From: [REDACTED]
Sent: 19 May 2023 12:48
To: Planning
Subject: RE: Matters of concern wishing to be noted for application 3/2022/0317 - re. Reserved Matters application in respect of Phase 5 and 6

Sent: Thursday, May 18, 2023 3:25 PM
To: Planning <planning@ribblevalley.gov.uk>
Subject: Matters of concern wishing to be noted for application 3/2022/0317 - re. Reserved Matters application in respect of Phase 5 and 6

Proposed Composite Layout Phases 5 & 6

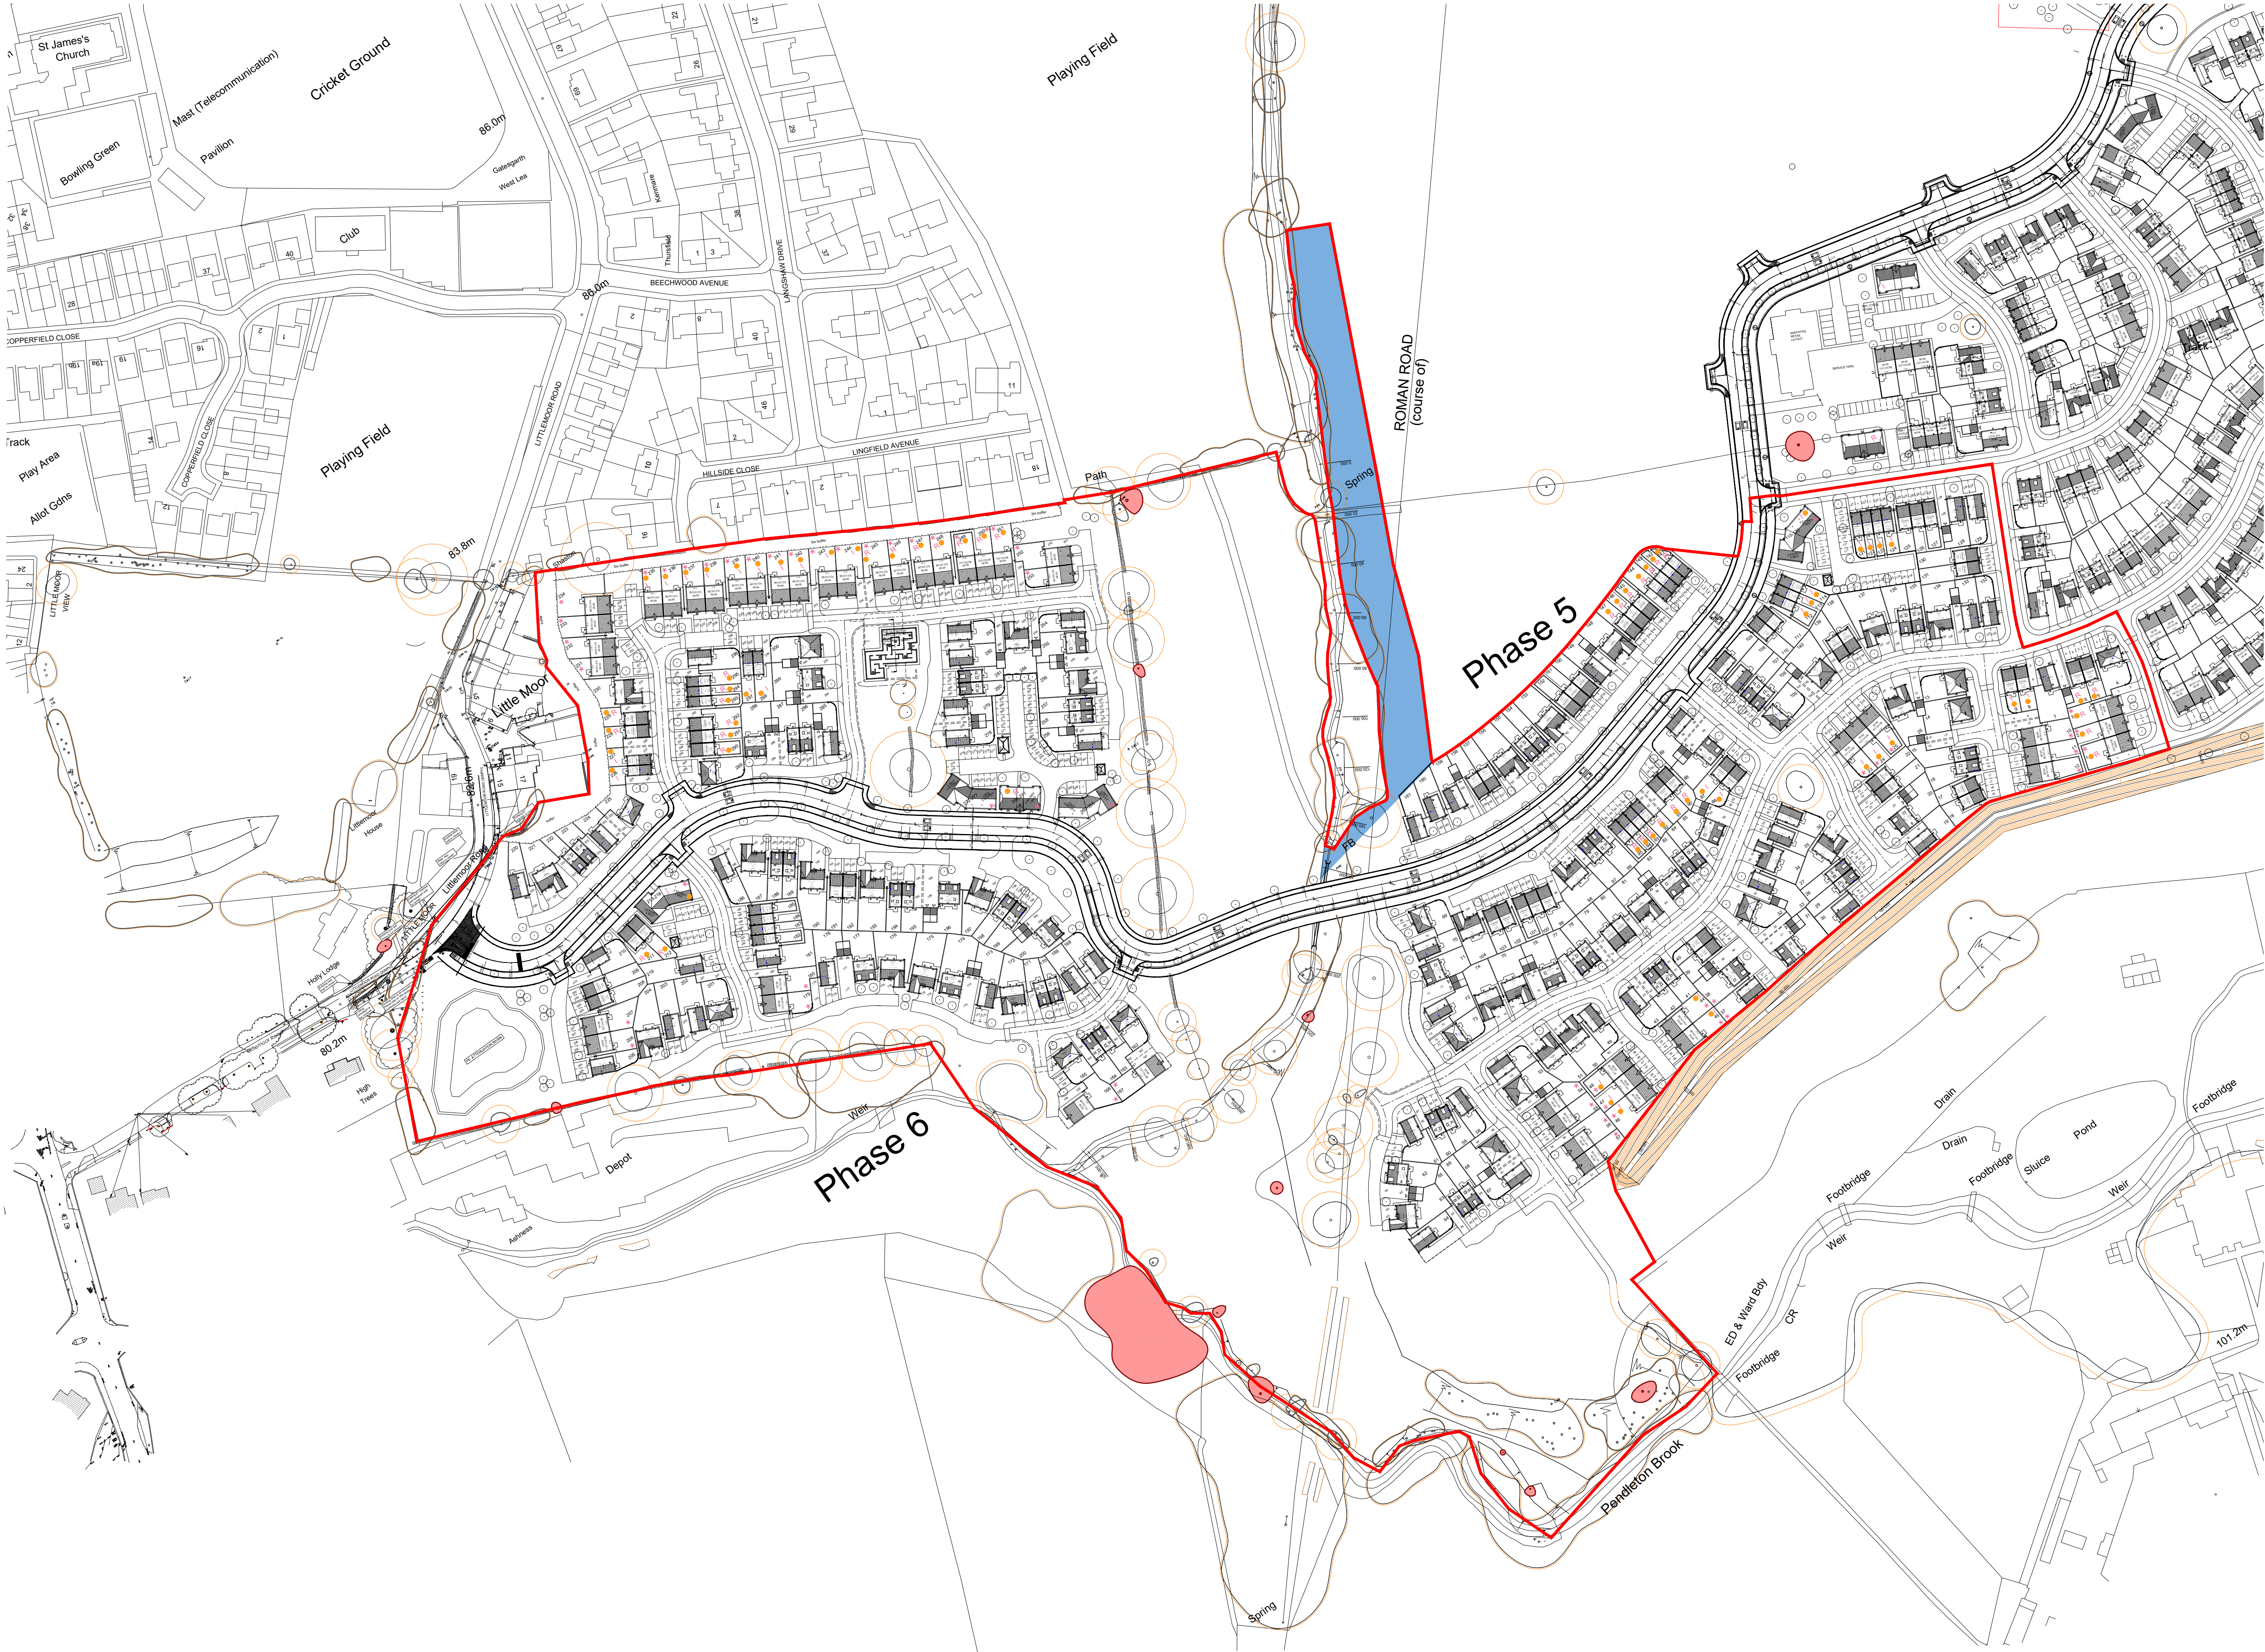
1. The application shows a significant change in the width and layout of the buffer zone compared to the one shown in the illustrative masterplan which was approved at outline stage (3/2012/0942). The illustrative masterplan shows a much **wider** buffer zone and one that is bordered firstly by a road and then houses; whereas this latest plan shows that the buffer zone is bordered by gardens and not a road. To propose that the use of the rear gardens of the new houses somehow provides a “true buffer” seems to miss the point of what a buffer zone is for and how it is best achieved.

3. The illustrative masterplan approved at outline stage (3/2012/0942) shows no houses adjacent to Littlemoor Road; to the left of the proposed new entrance (if one was standing on the road looking into the development area). This latest plan shows that houses are now going to be built on this area which was previously approved at the outline stage as being only grassland.

Client:	
Project Title:	
Residential Development	
Address:	
Higher Standen Farm, Clitheroe	
Drawing Title:	
Proposed Composite Layout Phase 6	
Drawing No:	
TW/HSF/PLP6/01	
Dwn: BDC	Ckd: ST
Date:	28/01/22
Scale:	Paper Size:
1:500	A1
	Rev: B

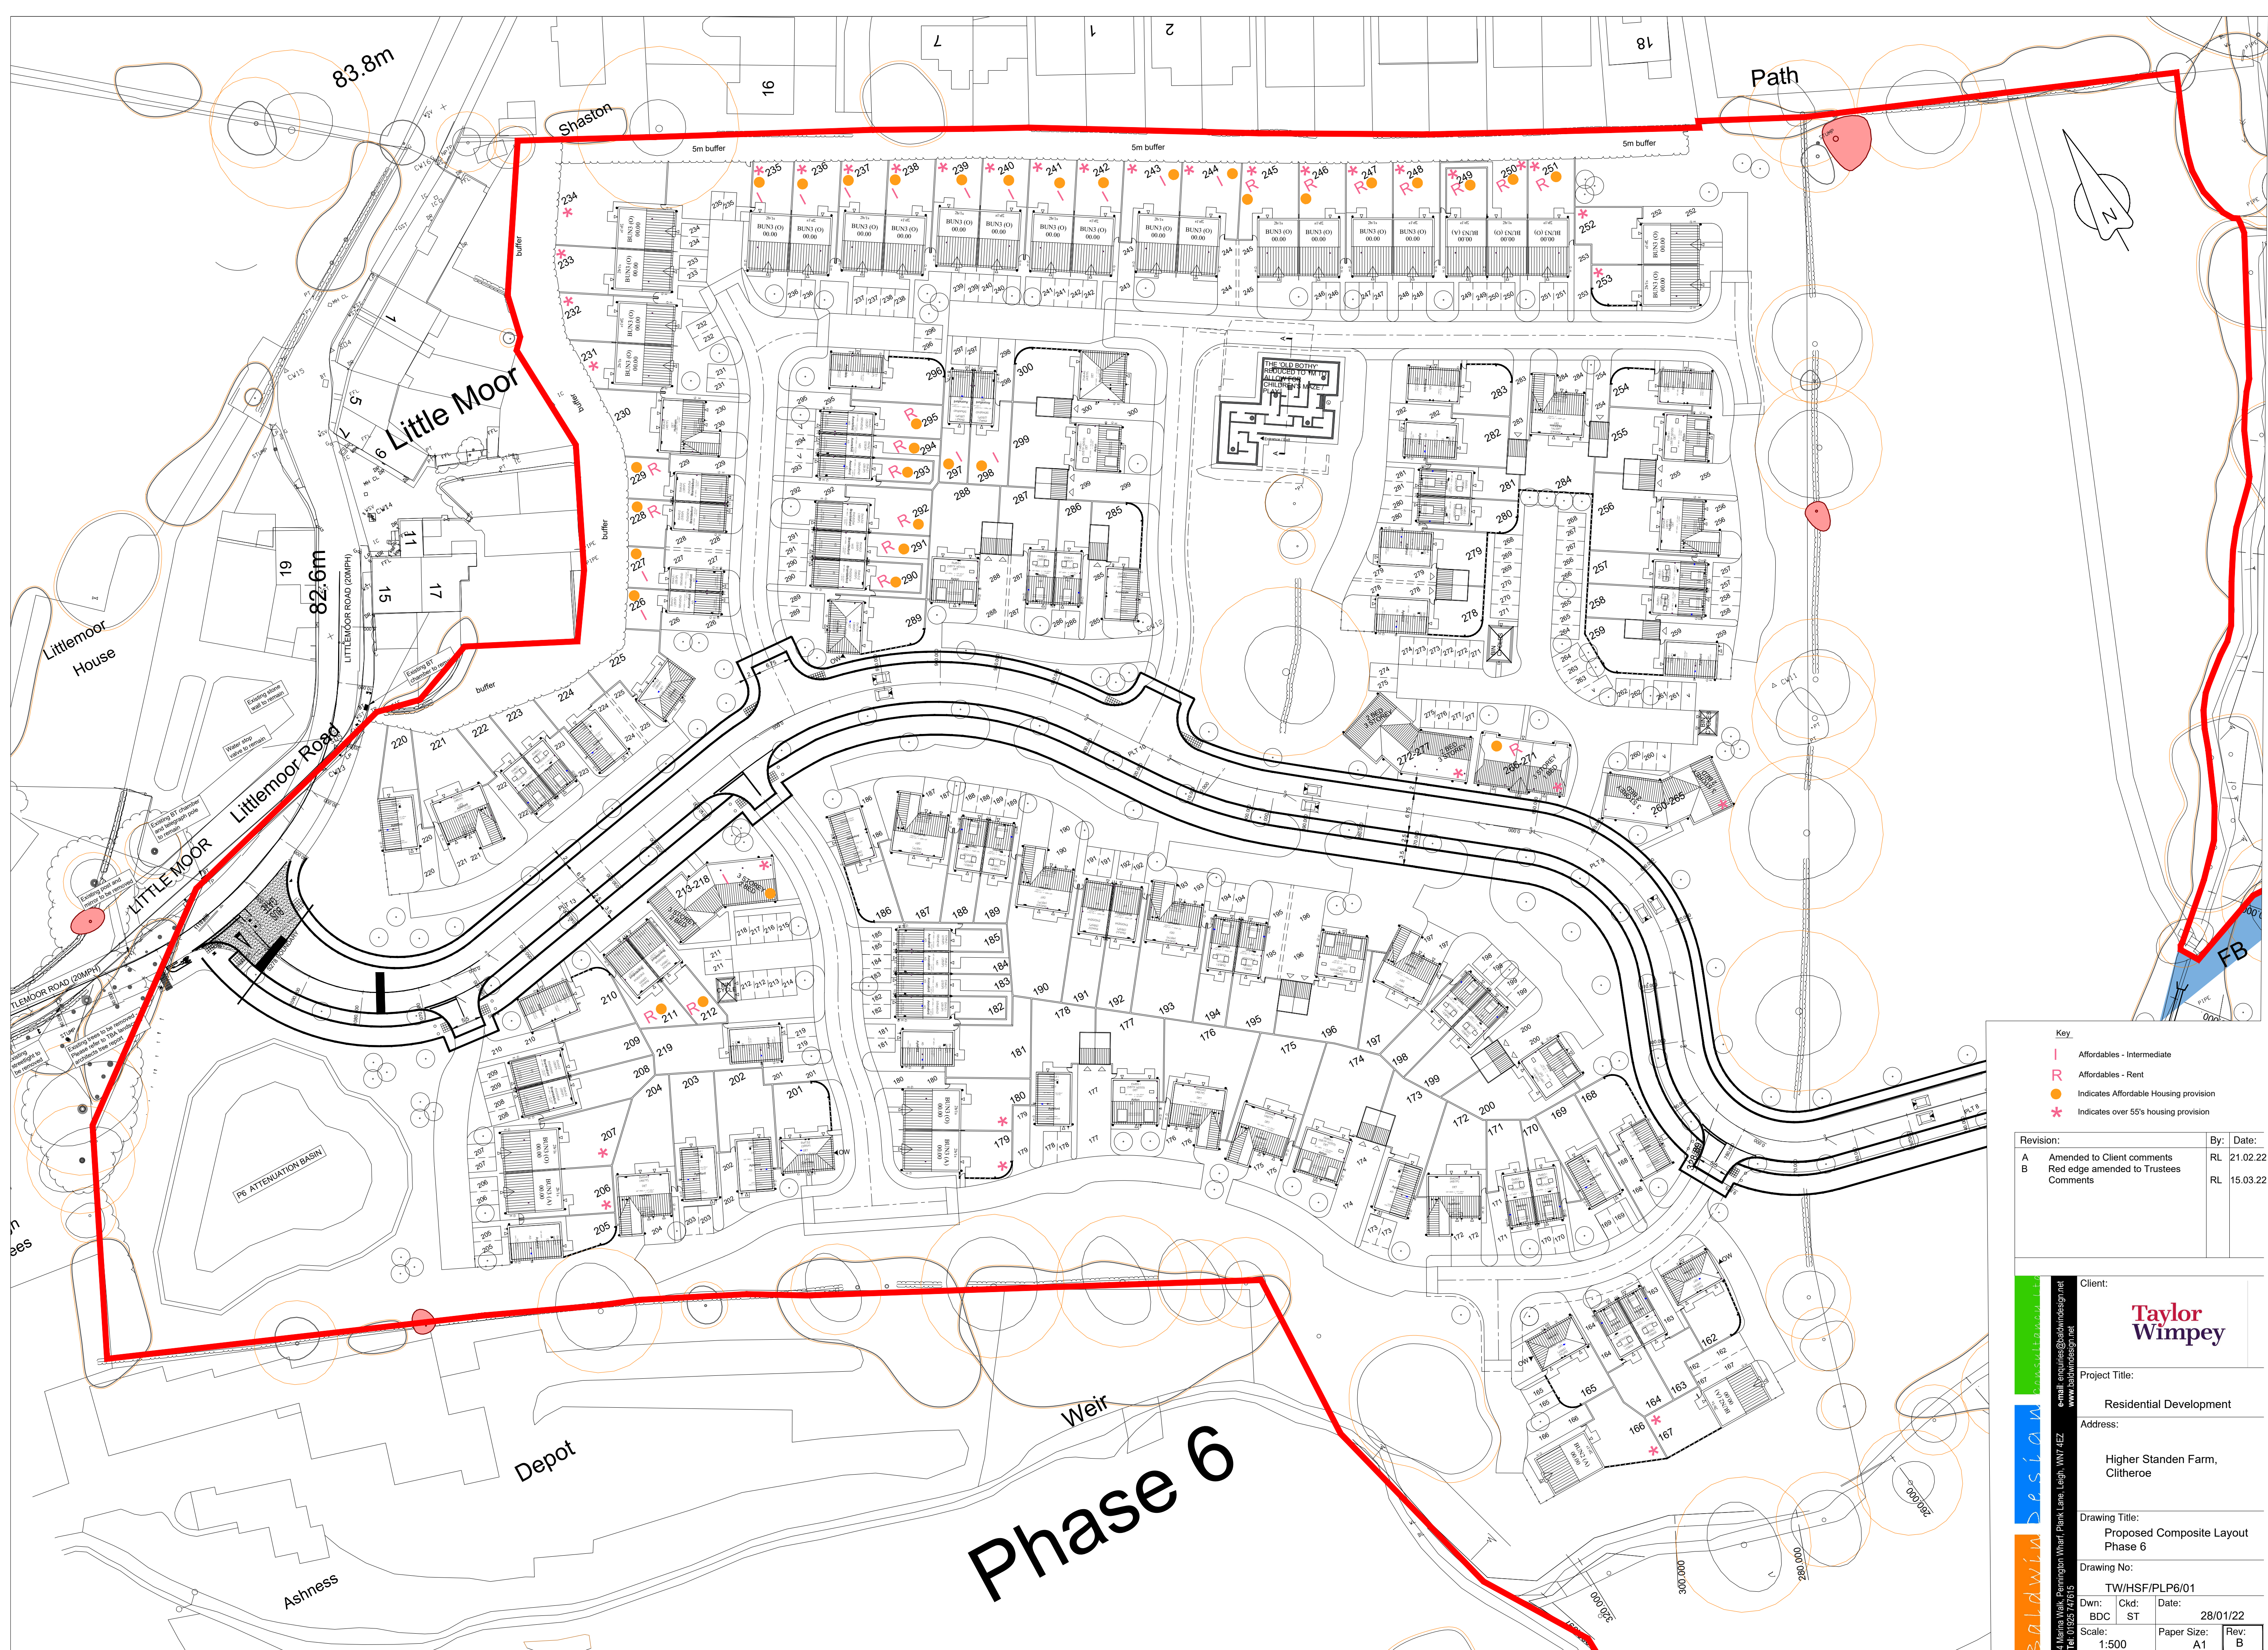
Further to [REDACTED] comments sent via [REDACTED] (18th May) for application 3/2022/0317 we have discovered that the illustrative plan we referred to in our previous email has since been superseded. For a different illustrative masterplan was approved under application 3/2015/0895. This different illustrative masterplan was submitted as part of an application which stated that its primary purpose was to request approval to commence phase 1 before constructing the roundabout on the A59 and request a change in the siting of the school and the business / retail area. It was not made clear in this application that the buffer zone width and layout would also be changing for phase 6.

When this application (3/2015/0895) was consulted upon there were relatively few official and third-party responses. The planning officer's report for this application shows that, like us, no one picked up on the fact that the phase 6 construction and buffer zone layout was changing significantly compared to the first illustrative masterplan – the one which was approved after much public consultation (application 3/2012/0942). The covering letter submitted by the developer's agent just mentions that they have prepared "*a new illustrative master plan to show what it considers to be a significantly improved layout across the whole site, and has prepared detailed plans for phase 1 which tally with the new masterplan*". With no mention that there has been a fundamental change to the width and layout of the phase 6 buffer zone and construction layout (siting of houses, roads etc).

[REDACTED] by the developers into allowing a fundamental change to take place to the width and layout of phase 6 without stating it clearly in their application. The new illustrative plan shows it but they do not highlight the changes compared to the previous illustrative masterplan. [REDACTED]
